1. **Project # PR-2020-003707**
SI-2020-00247 – SITE PLAN

RESPEC agent(s) for SONATA TRAILS, LLC request(s) the aforementioned action(s) for all or a portion of: **TRACTS 1, 2 & 3, UNIT 4**, zoned MX-M, located at **UNIVERSE BLVD NW between PASEO DEL NORTE BLVD and TREELINE AVE NW**, containing approximately 29.9 acre(s). (C-10)

PROPERTY OWNERS: SONATA TRAILS LLC
REQUEST: APARTMENT COMPLEX DEVELOPMENT

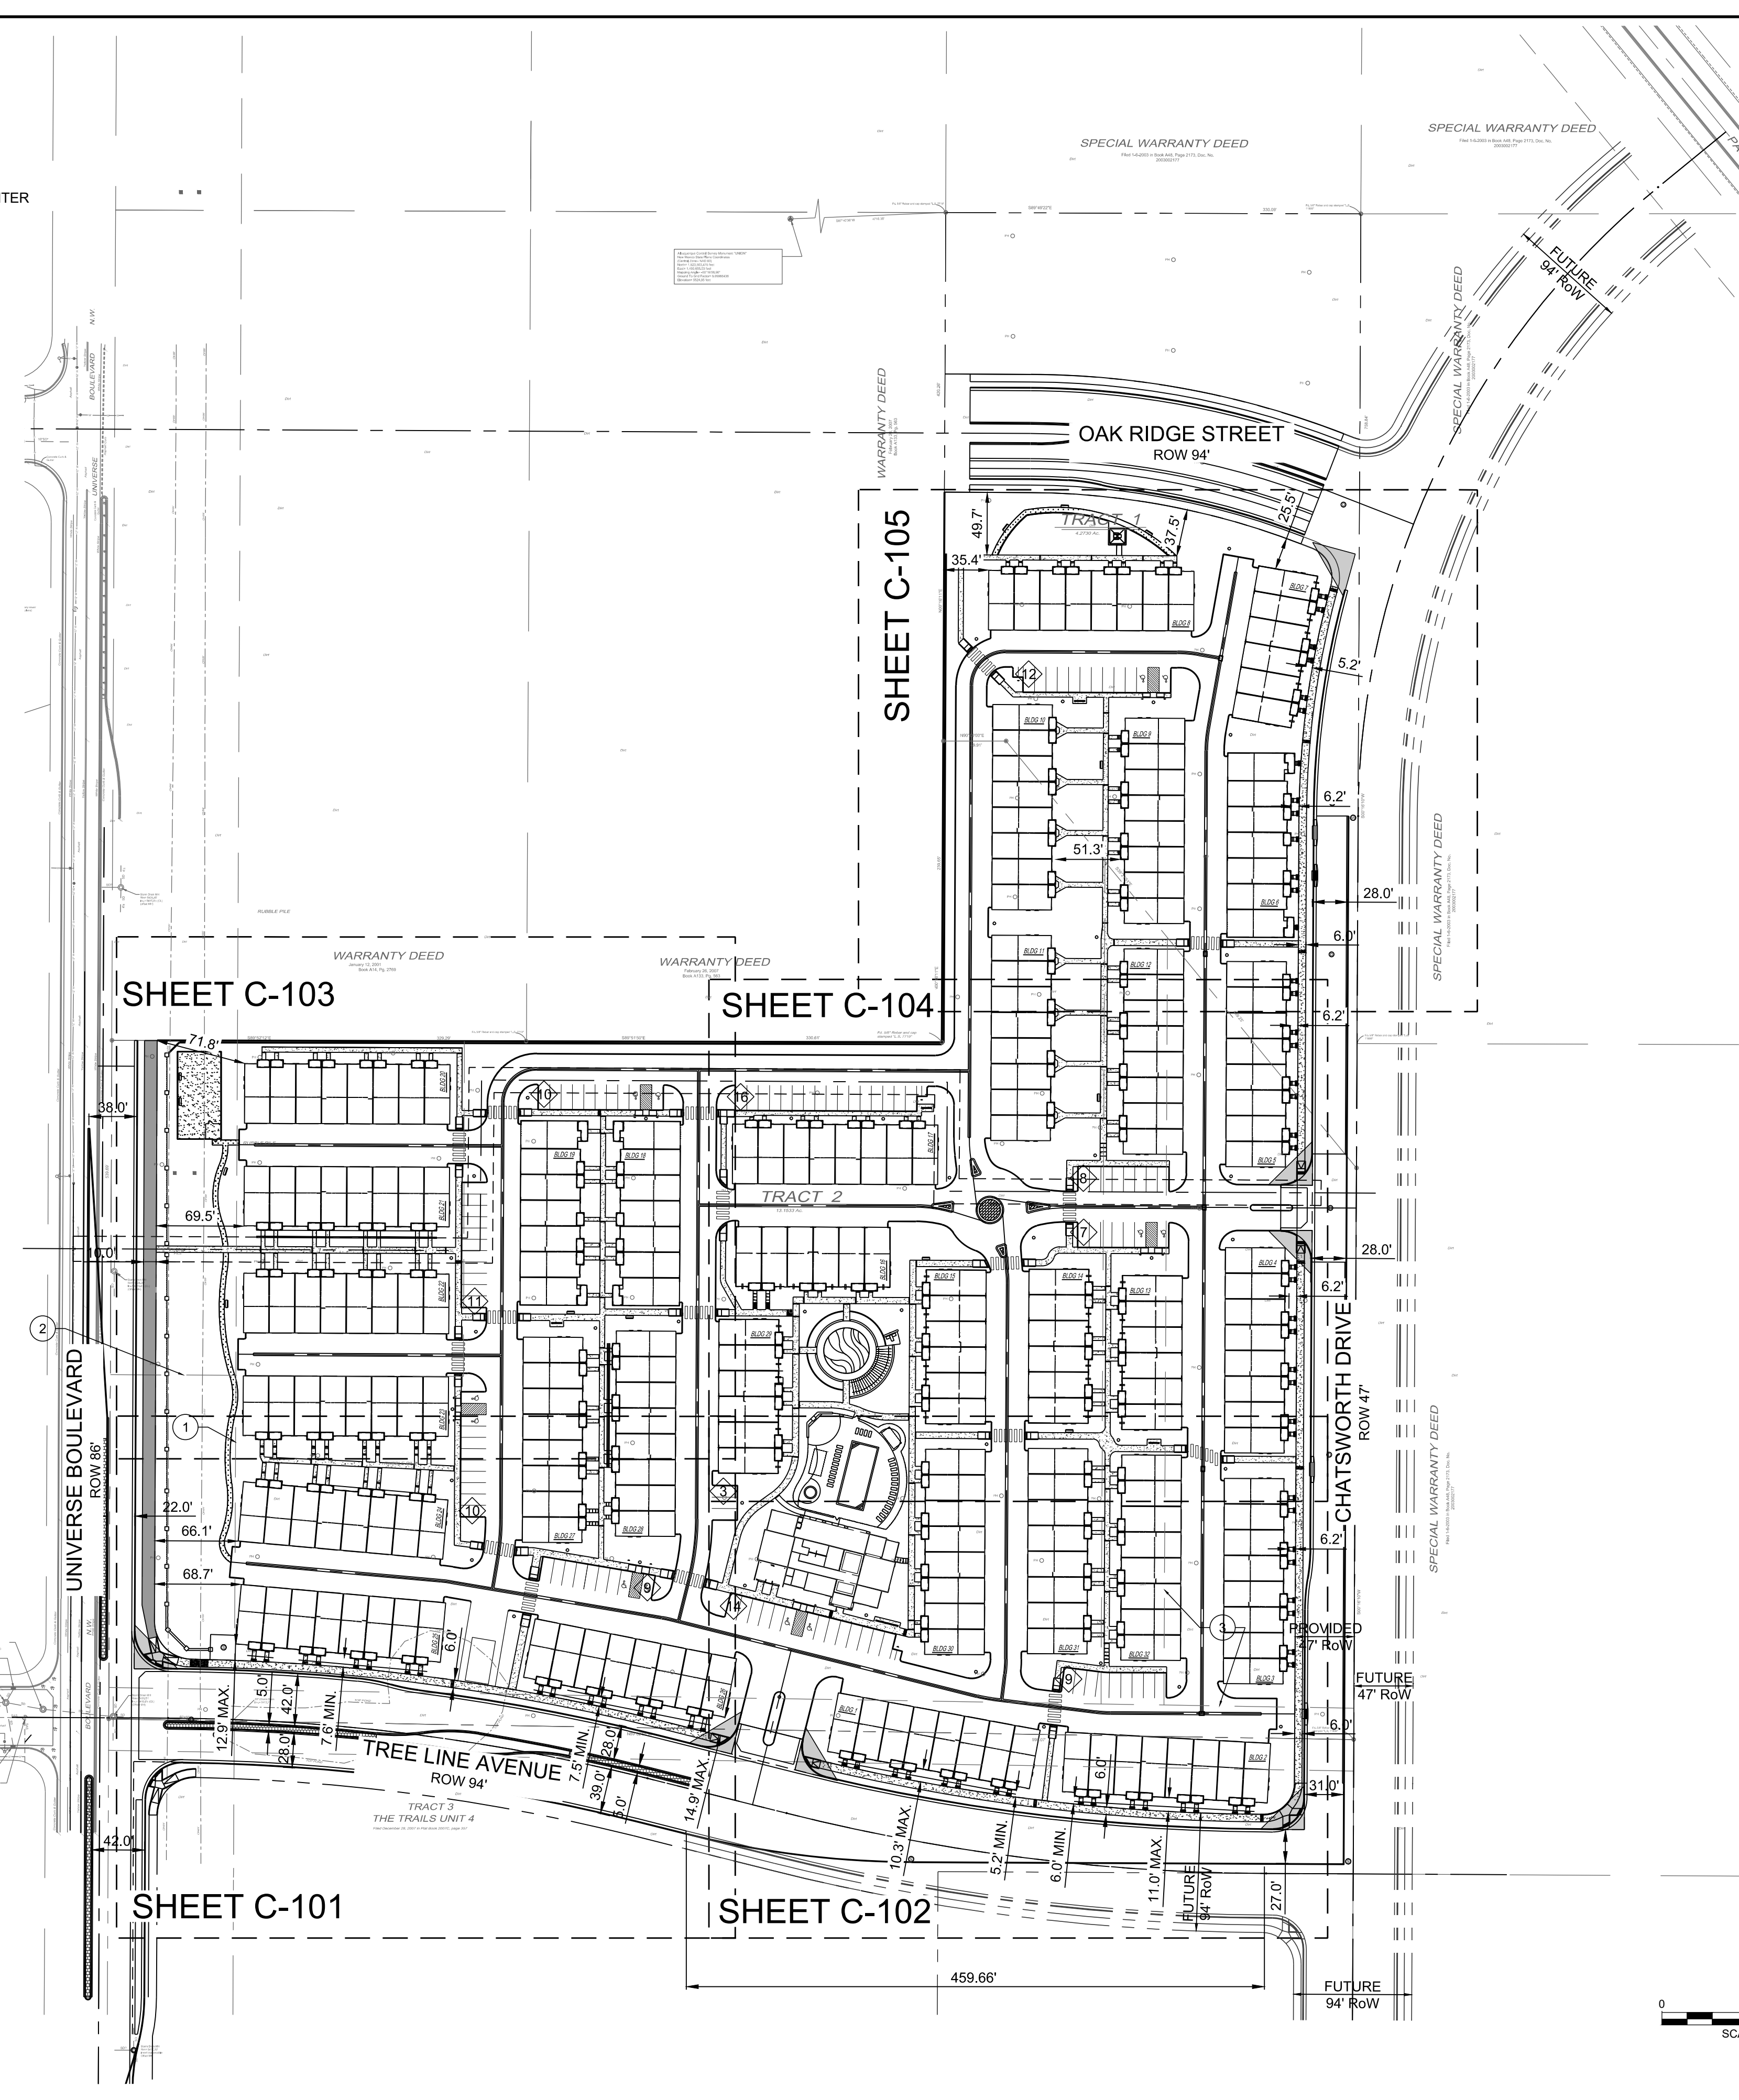
Transportation: How does this project incorporate the Future Loop Road illustrated in the Volcano Heights Sector Plan? Specifically, at the north end and east boundary of the proposed development. The Loop Road is critical to bring the four quadrants surrounding the Unser and Paseo Del Norte intersection within the Volcano Heights Urban Center. The NEC of Tract 1 should have a design that addresses the volume of traffic anticipated when the future Oakridge Rd. intersects with Paseo Del Norte.
